Our Ref: ID 3850
Your Ref: SSD-65595459

2 June 2026

State Significant Development Application for Hunter Indoor Sports Centre (HISC)

Title:
**2% AEP Flood Hazard Classification for
Post-development Conditions**

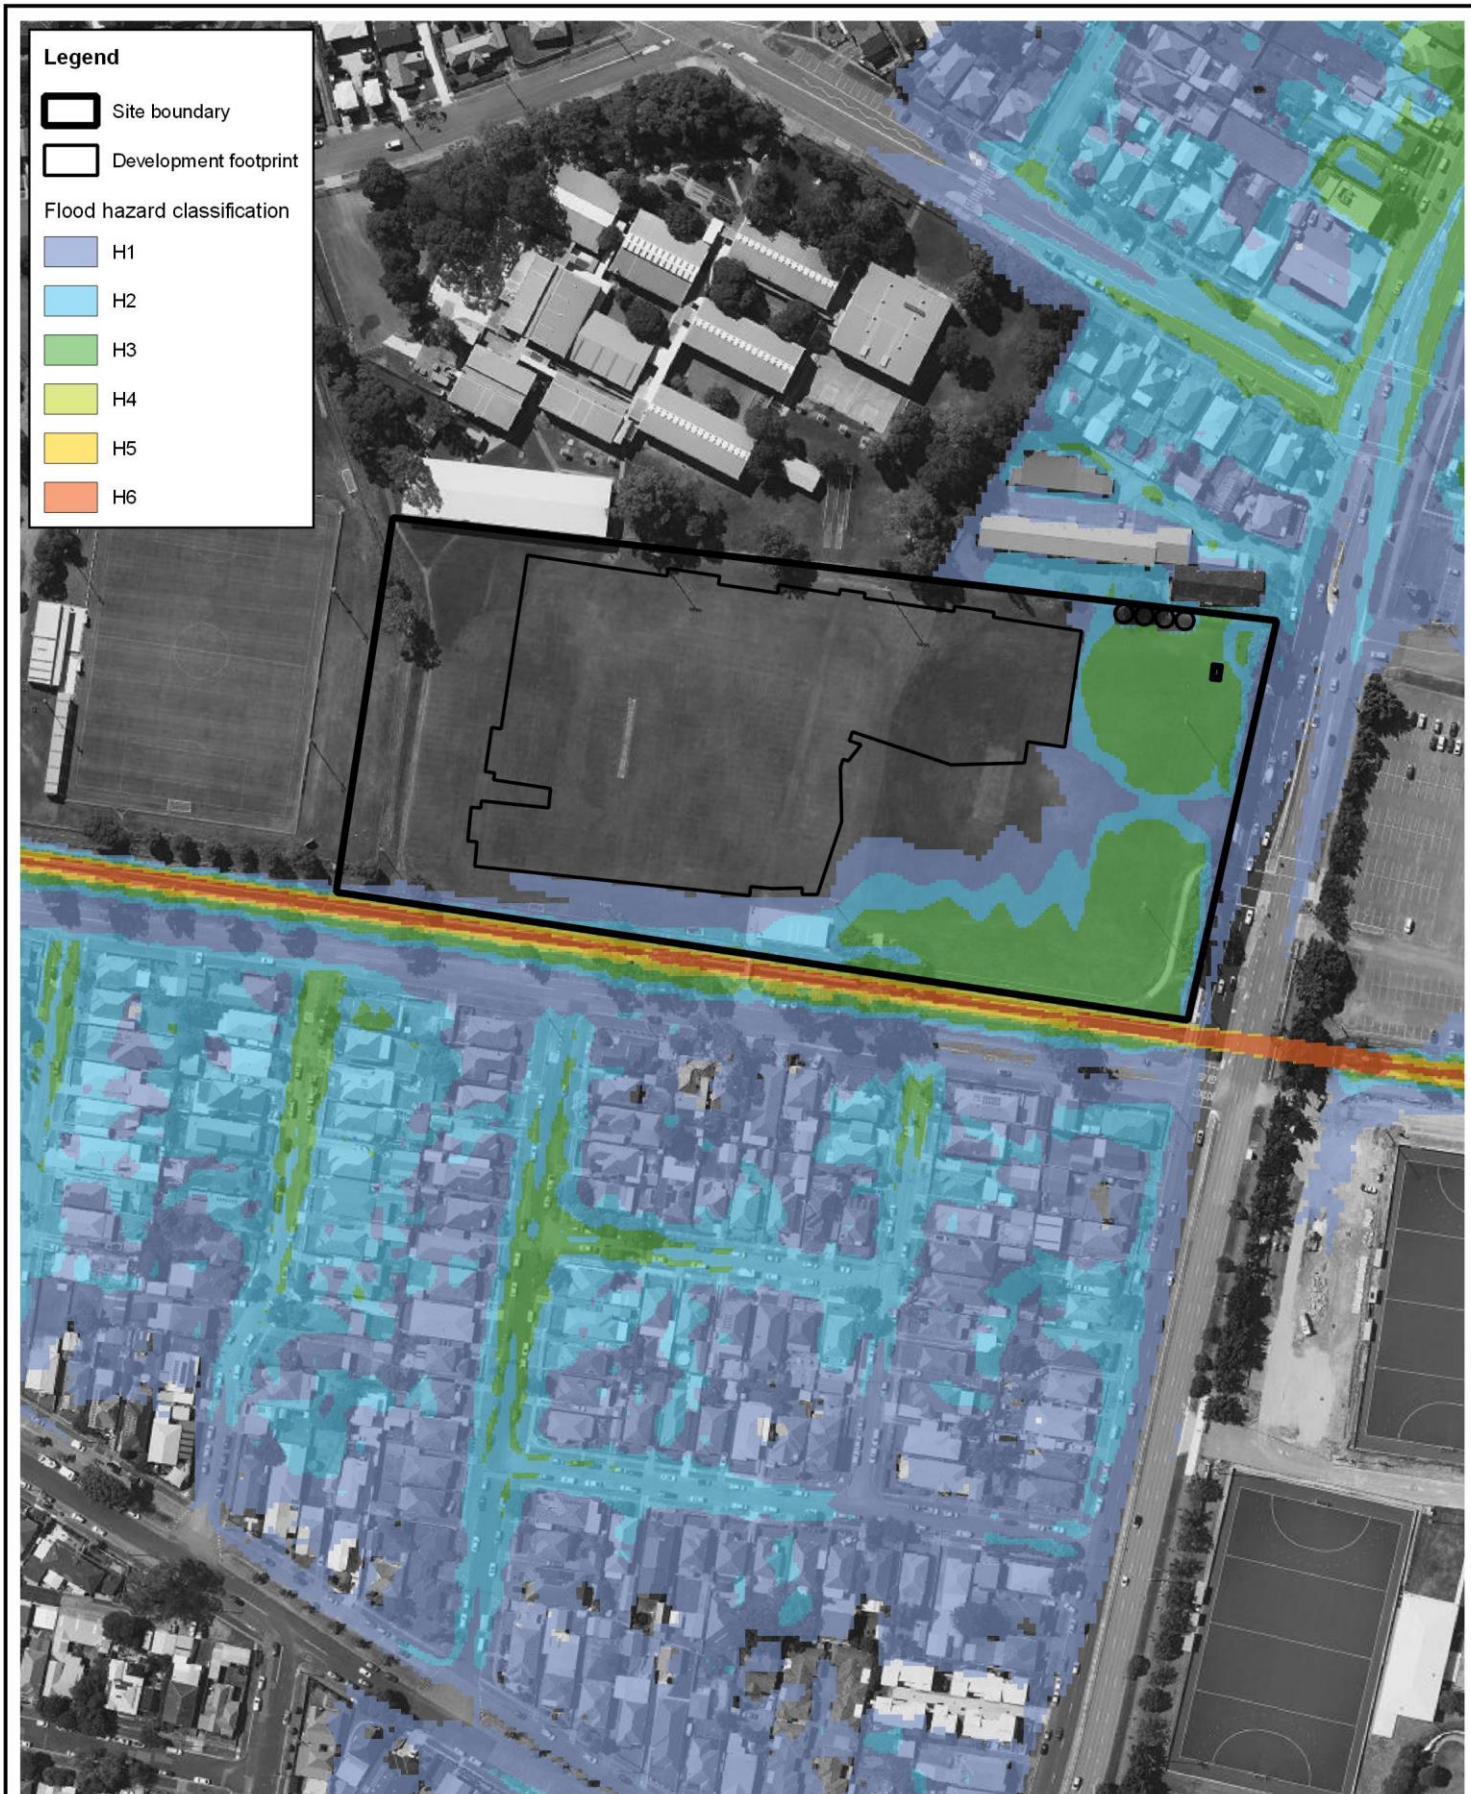
In a 5% Annual Exceedance Probability (AEP) event post-development conditions there is some low hazard (H1) flood affectation around the site access point onto Turton Road²,

² Torrent Consulting. 2026. Hunter Indoor Sports Centre – Flood Impact and Risk Assessment (Revision 09), Figure B-6

increasing to H3 hazard level flooding in a 1% AEP event.³ Flooding progressively encroaches onto the site, with complete inundation occurring in the Probable Maximum Flood (PMF) event, and **high hazard flooding (H5 flood hazard level)** along the site's southern boundary and the entire eastern part, including access onto and Turton Road itself experiencing high hazard flooding.⁴ The site and surrounds are subject to inundation periods of **6 to 9 hours**.⁵

B-8

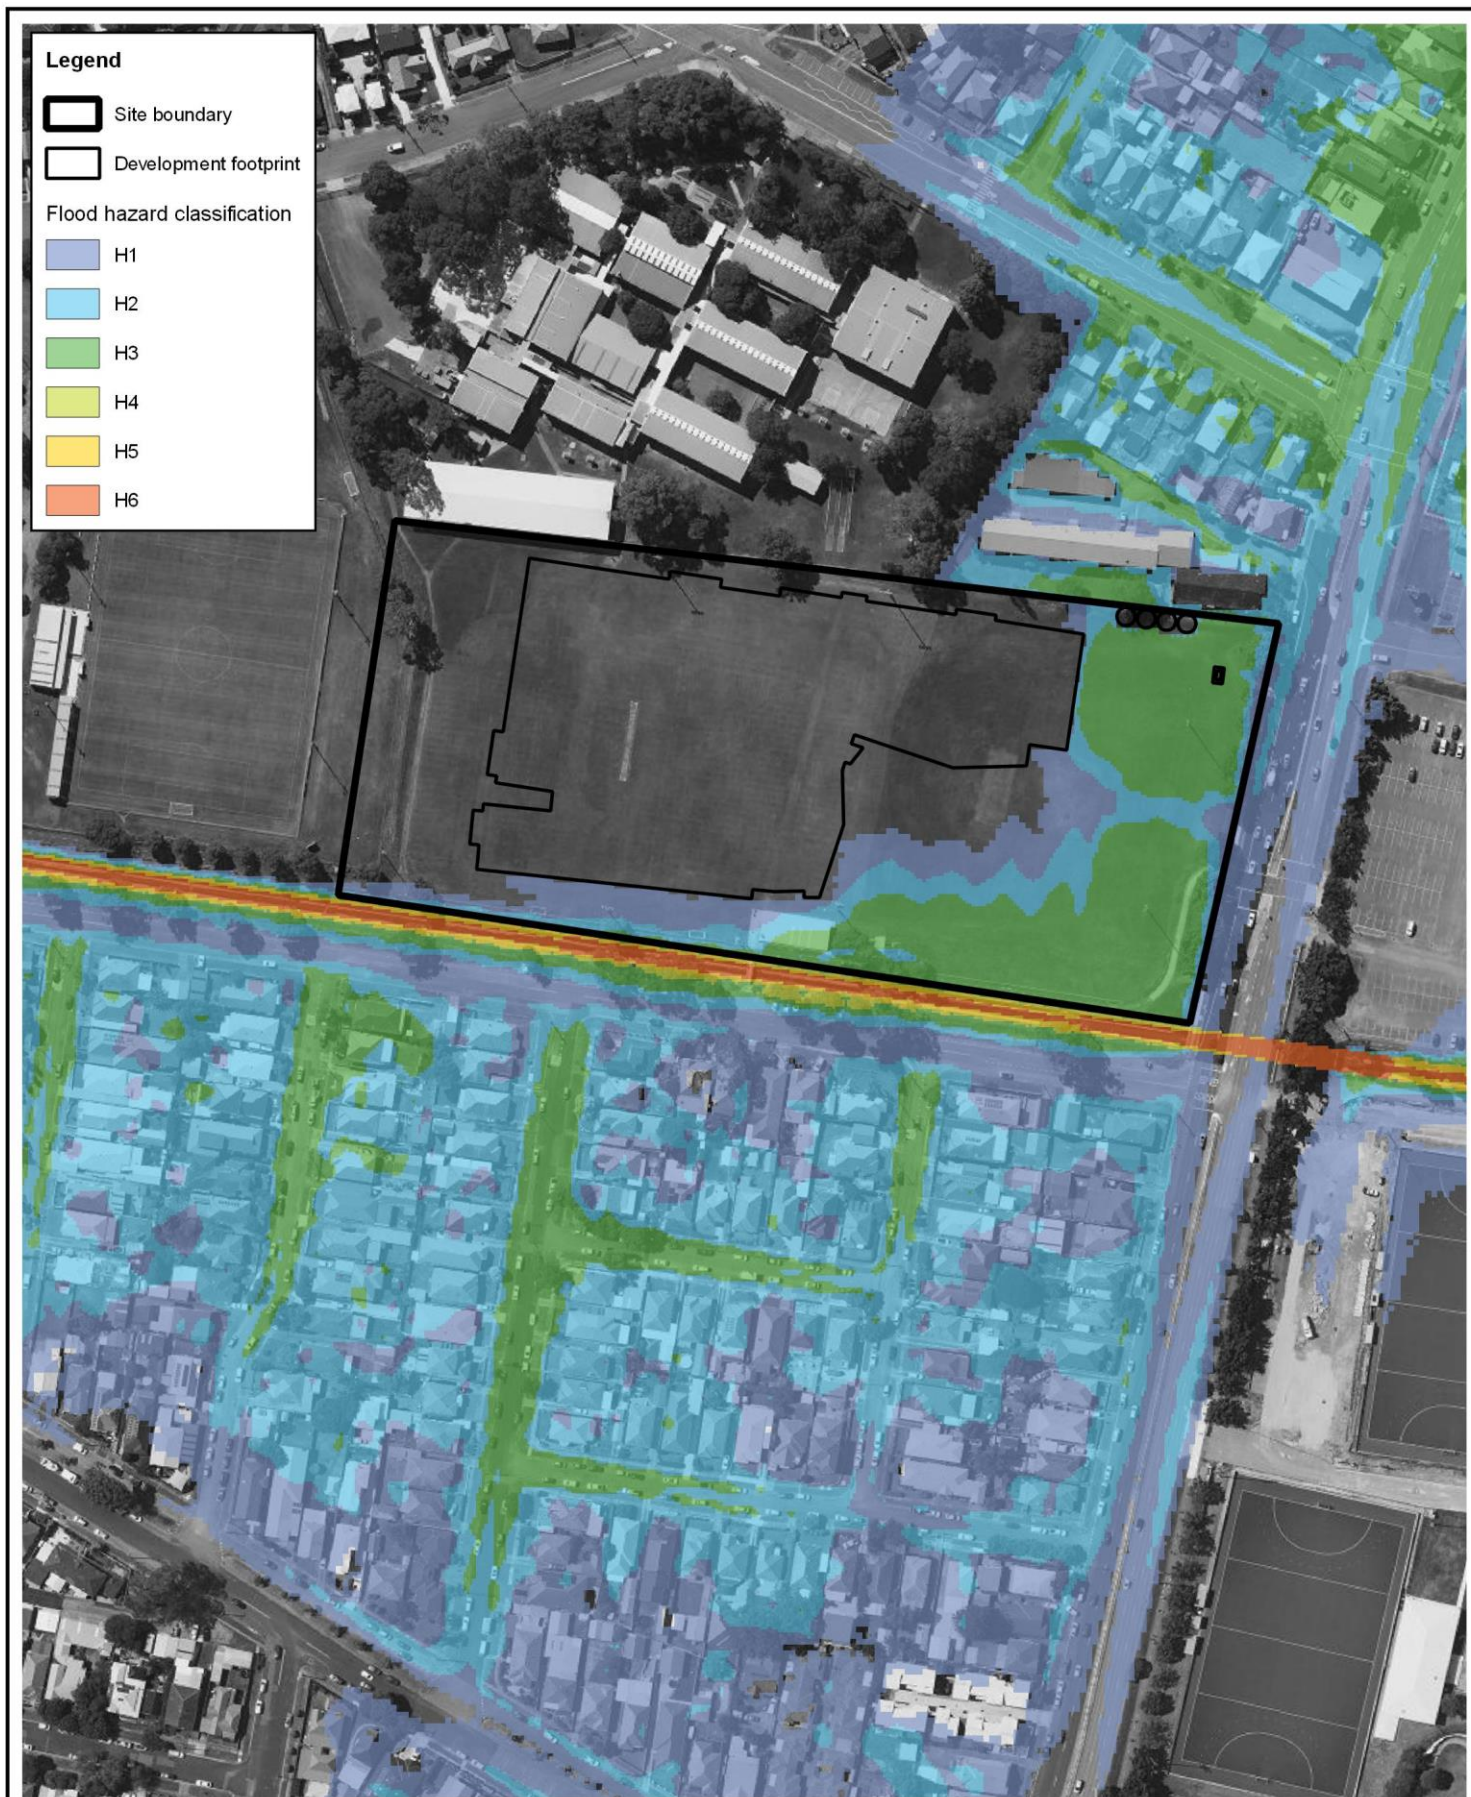
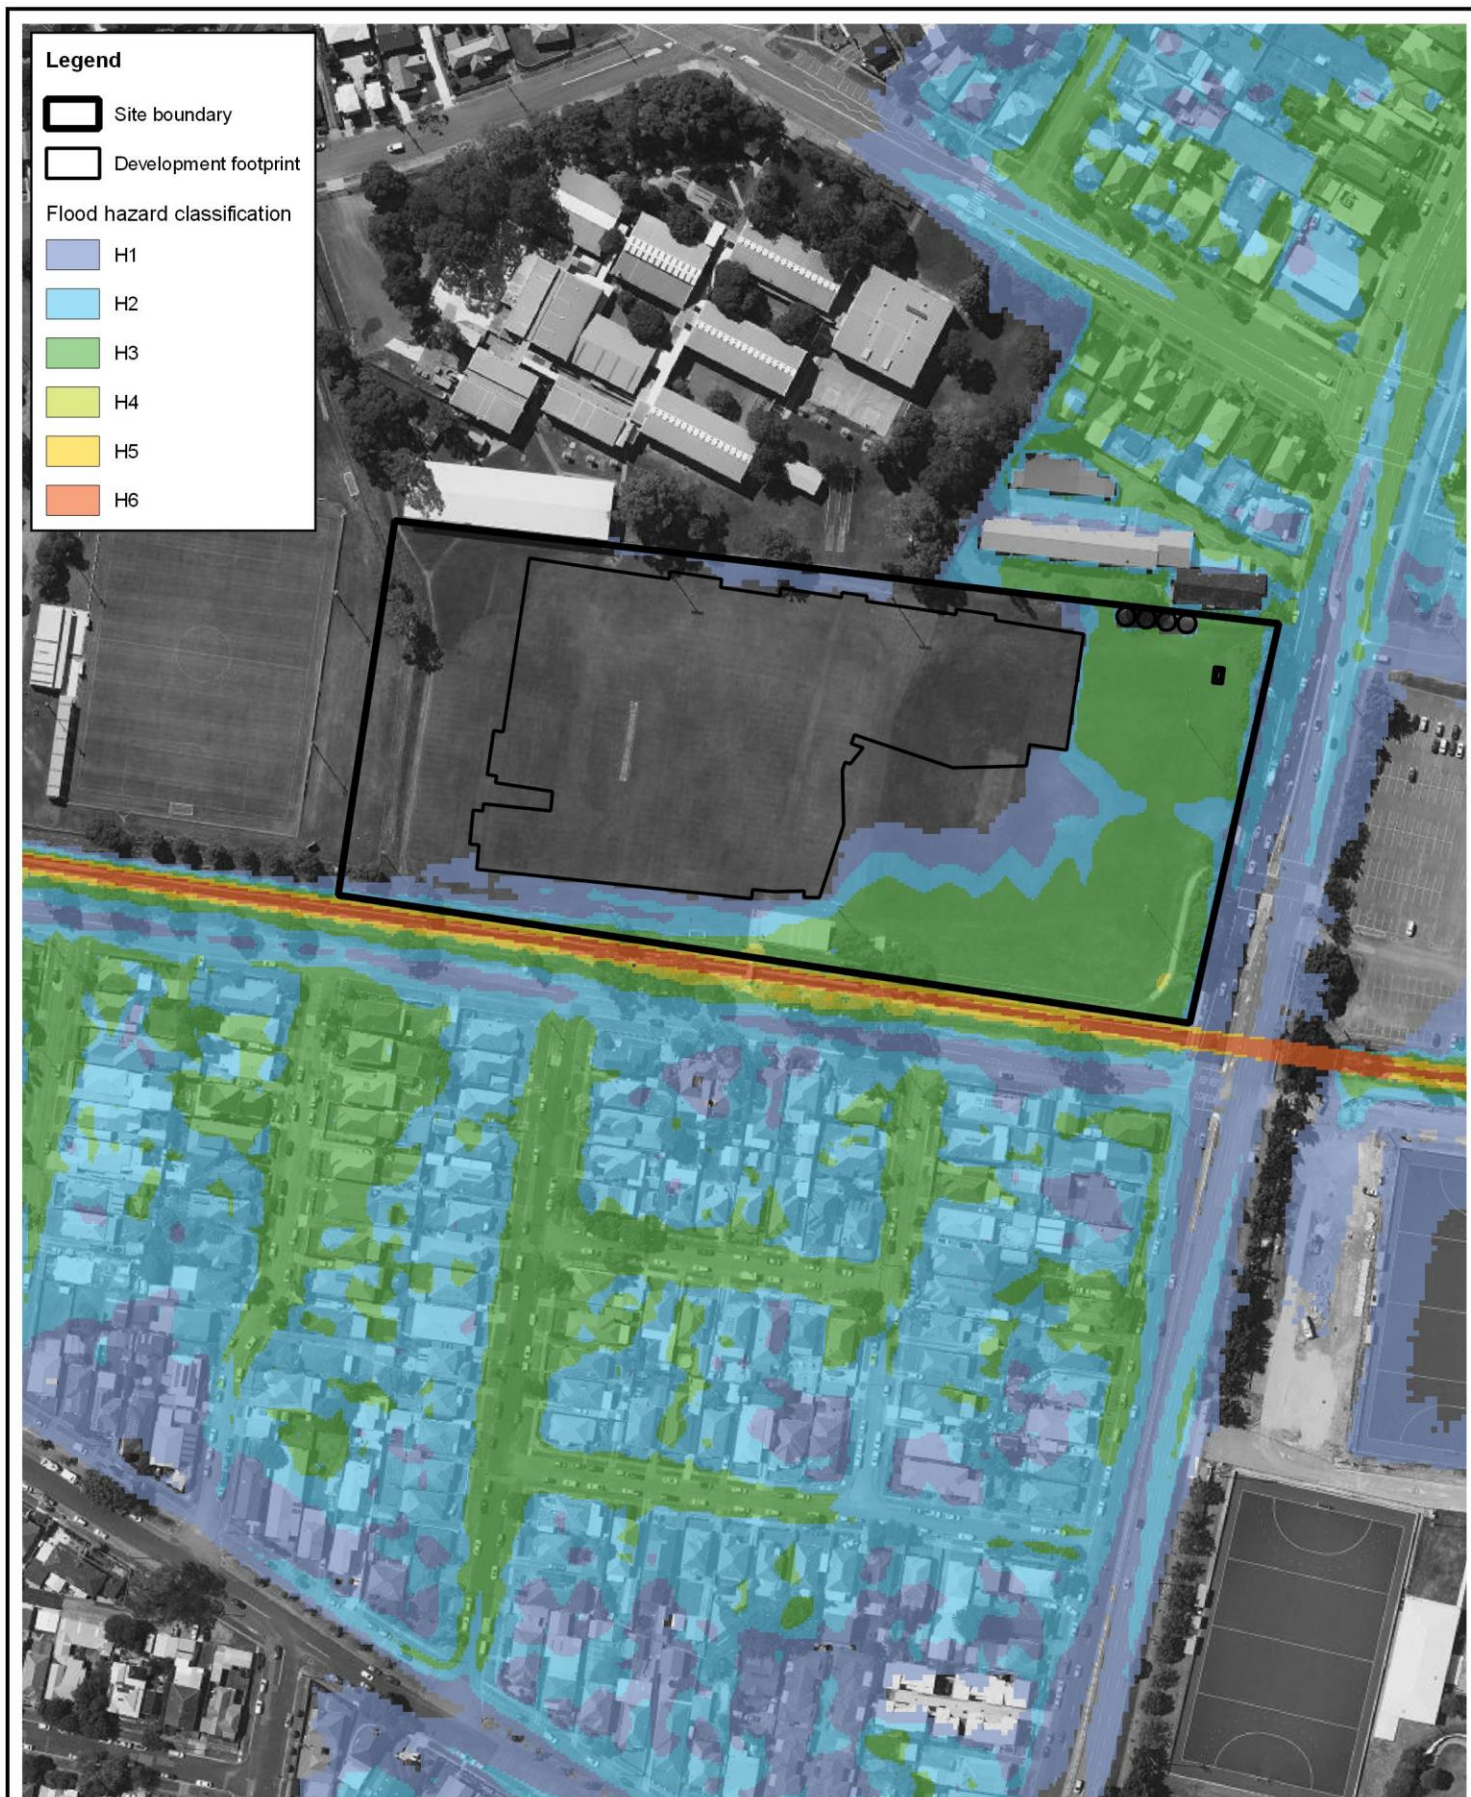
- **Reiterate** that any access/egress route impacted by H3 – H4 hazard level flooding⁹ **is not a safe available overland escape route**.¹⁰ The suggestion for people to navigate medium hazard floodwaters is **unacceptable, as it can put people's lives at significant risk**, and any such suggestions **must be removed** from the Flood Emergency Response Plan (FERP).

³ Torrent Consulting. 2026. Hunter Indoor Sports Centre – Flood Impact and Risk Assessment (Revision 09), Figure B-7 & B-8

C-1

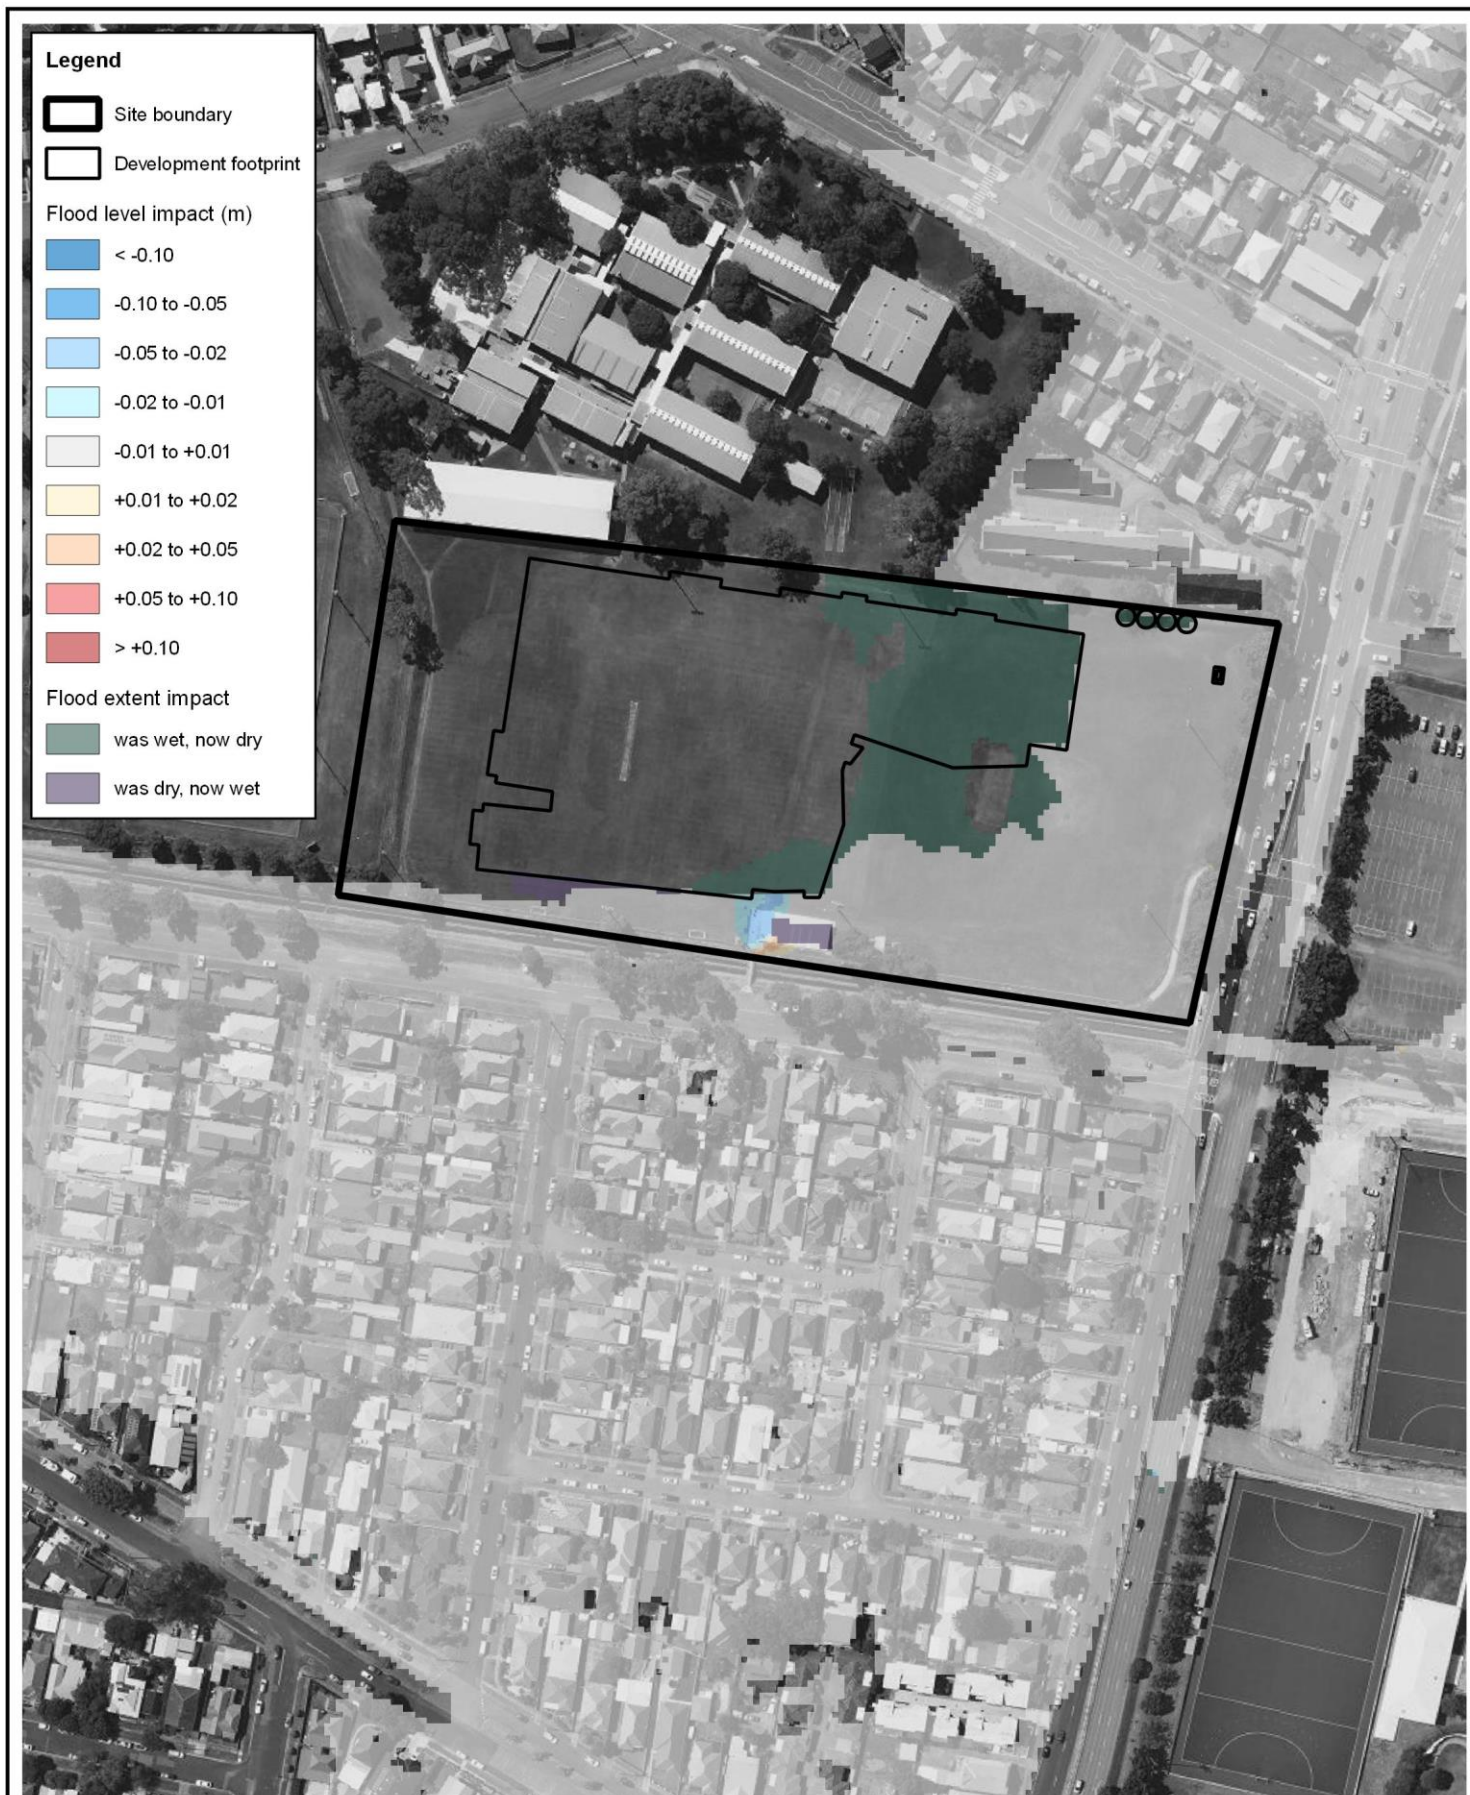
In a 5% Annual Exceedance Probability (AEP) event post-development conditions, flooding within the site is generally contained within the swale, with some low hazard (H1) flood affectation around the site access point onto Turton Road.²³ The modelling suggests that in post-development scenario, flooding conditions in the eastern part of the site, including around the site entry to slightly improve, showing a reduction in flood levels in events more frequent than the 2% AEP.²⁴ However, site vehicular access is cut in events rarer than the 2% AEP event, with access/egress onto Turton Road cut by H3 hazard level flooding in a 1% AEP event.²⁵ Flooding progressively encroaches onto the site, with complete inundation occurring in the Probable Maximum Flood (PMF) event, with **high hazard flooding (H5 flood hazard level)** along the site's southern boundary and the entire eastern part, including access onto and Turton Road itself experiencing high hazard flooding.²⁶

²⁴ Torrent Consulting. 2026. Hunter Indoor Sports Centre – Flood Impact and Risk Assessment (Revision 09), Figure C-1 & C-2
